Current Zoning: UMUD-O SPA (uptown mixed-use district, optional, site plan amendment)
Proposed Zoning: UMUD-O SPA (uptown mixed-use district, optional, site plan amendment)

Approximately 1.48 acres located at the east side of the intersection of South Church Street and West Brooklyn Village Avenue, along the northwest side of South Tryon Street.

The petition proposes to allow two 1,880 square foot skyline signs. The site is developed with an office tower.

Staff recommends approval of this petition upon resolution of technical revisions related to site and building design.

G01-01

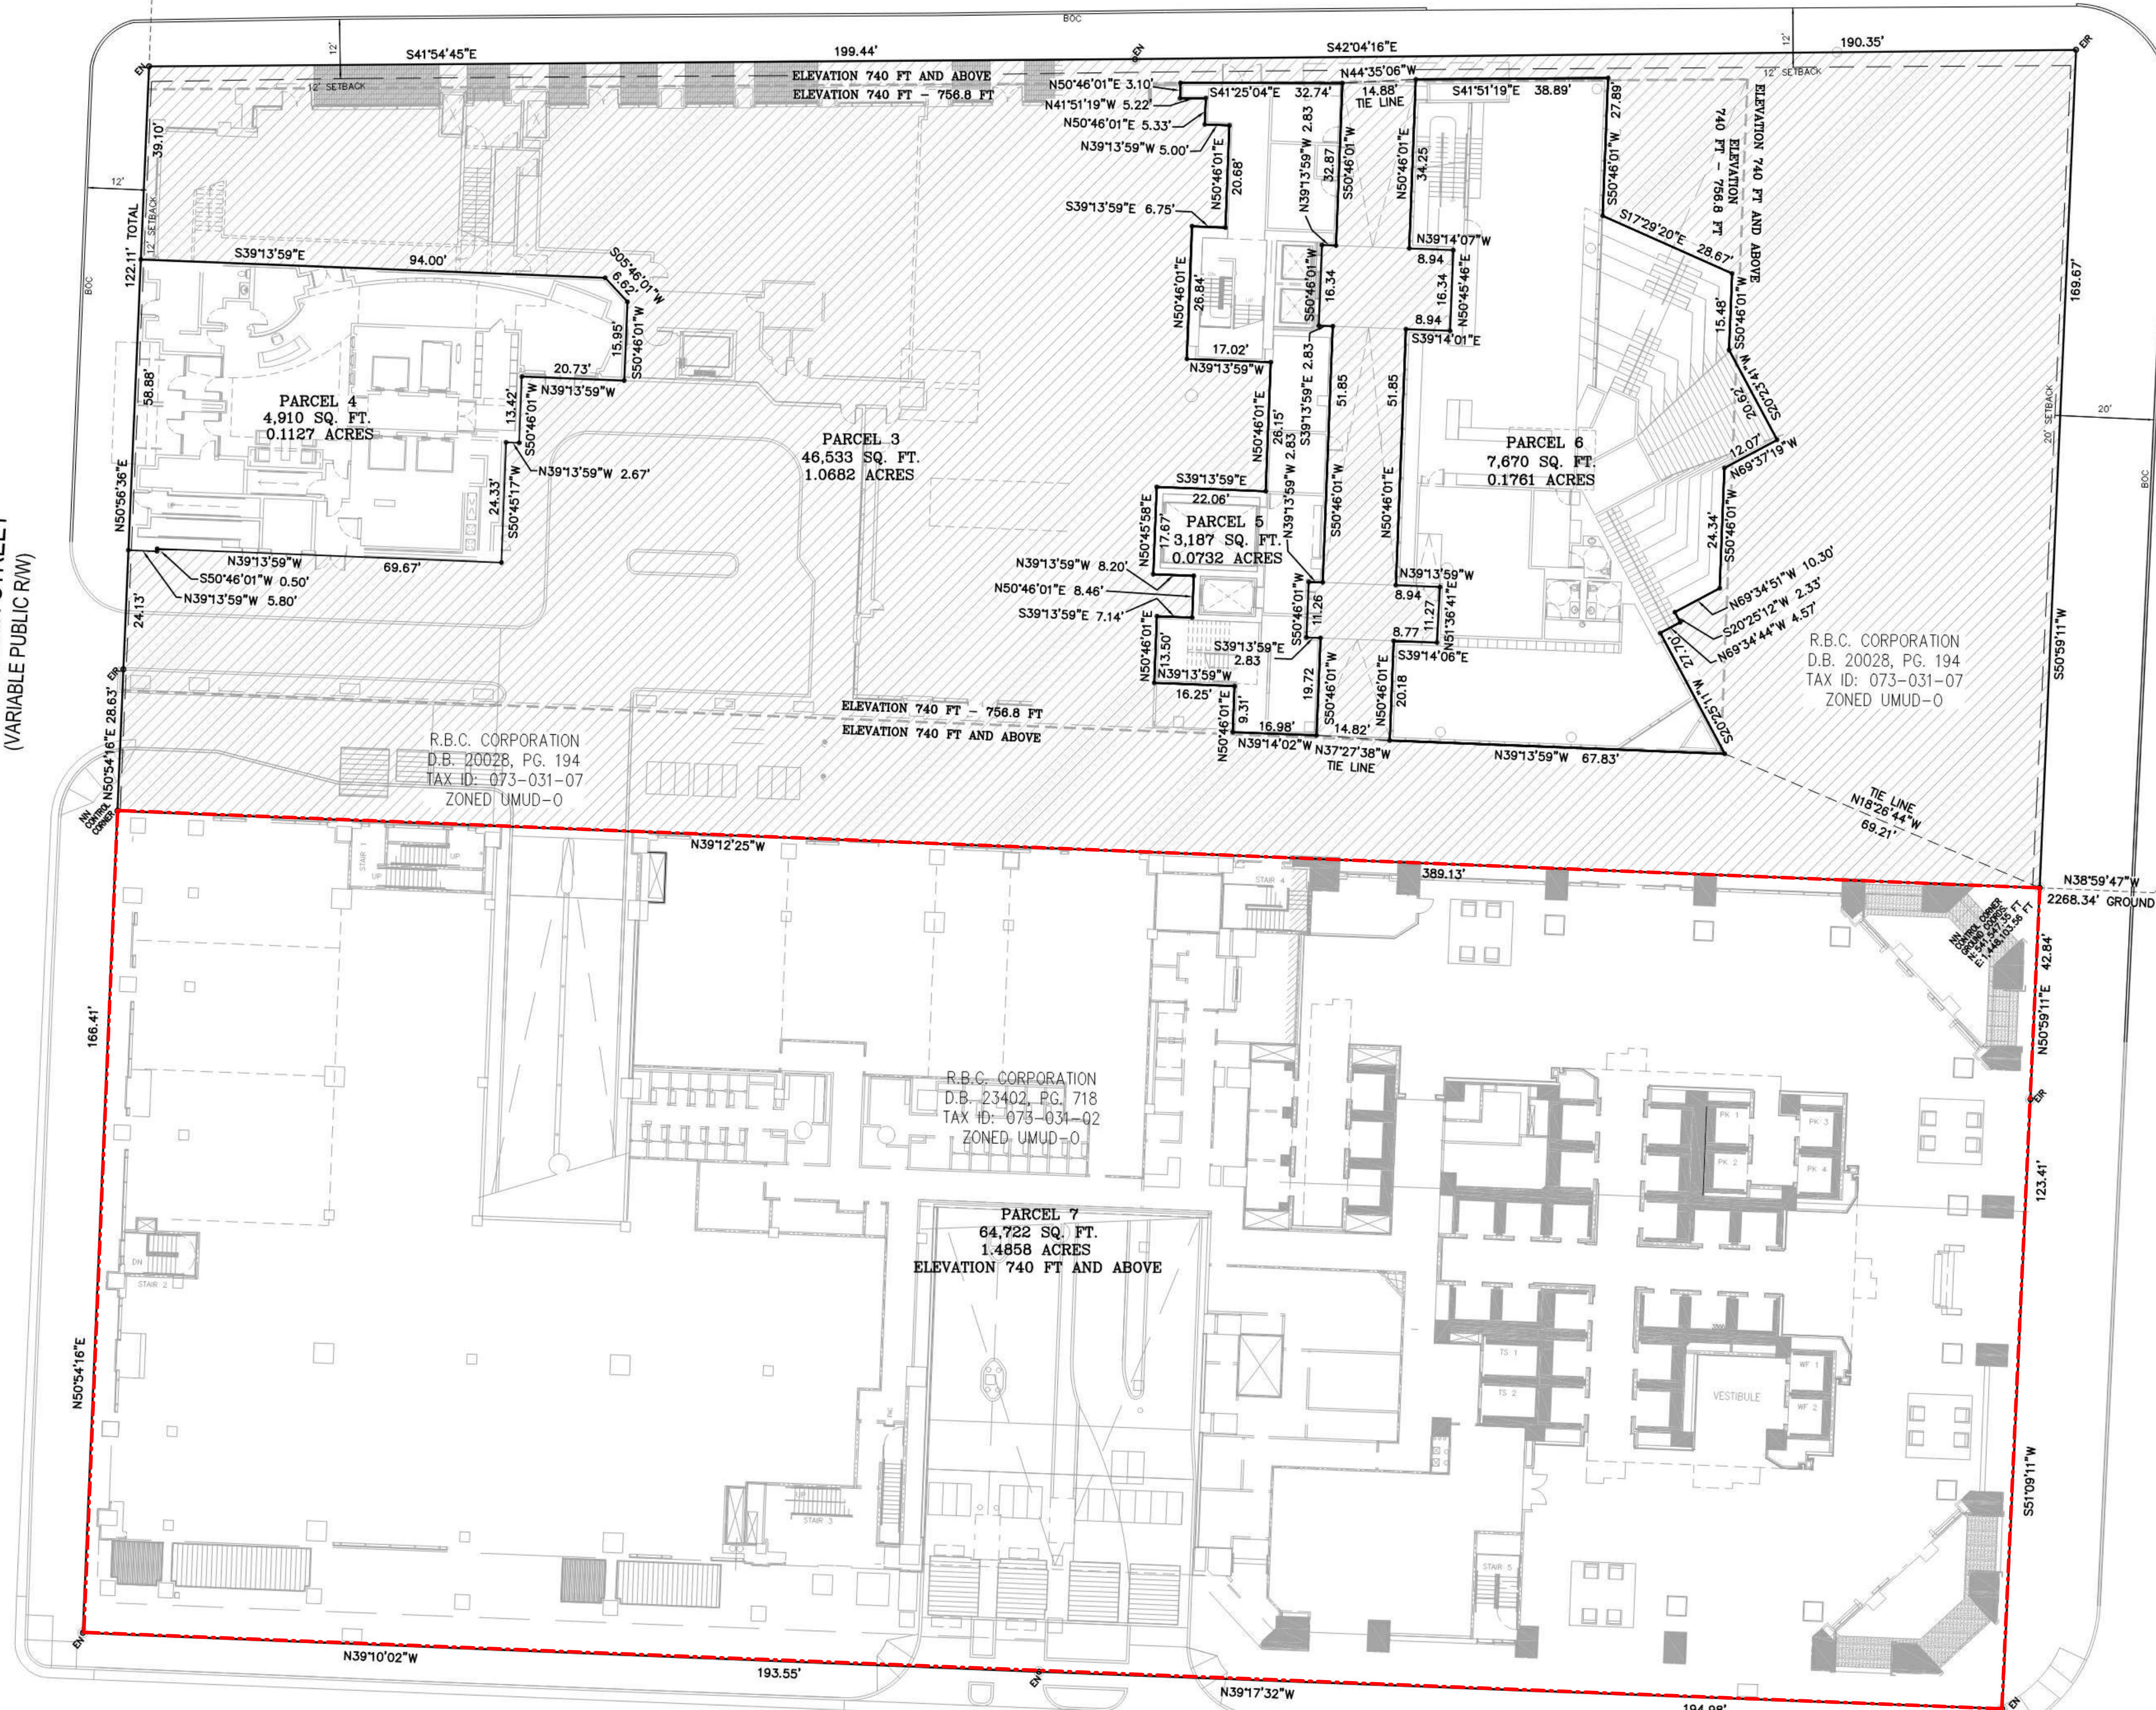
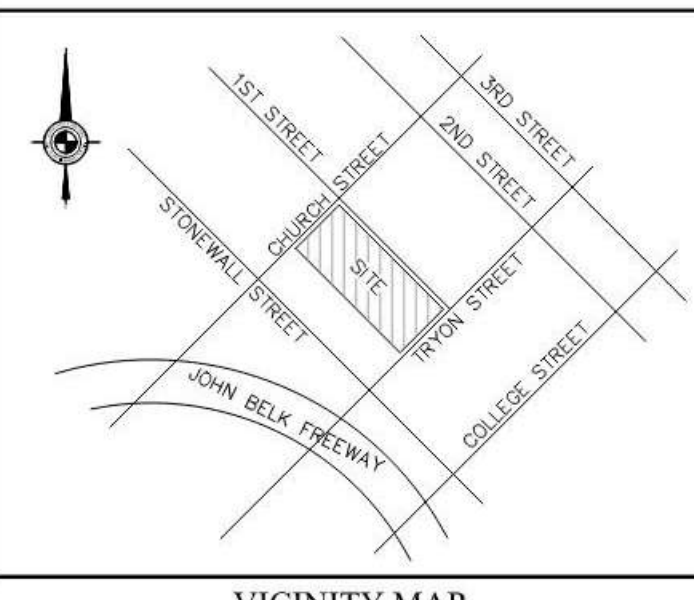
1. Update proposed optional provisions to specify that the requested skyline sign be made up of channel letter construction.
-
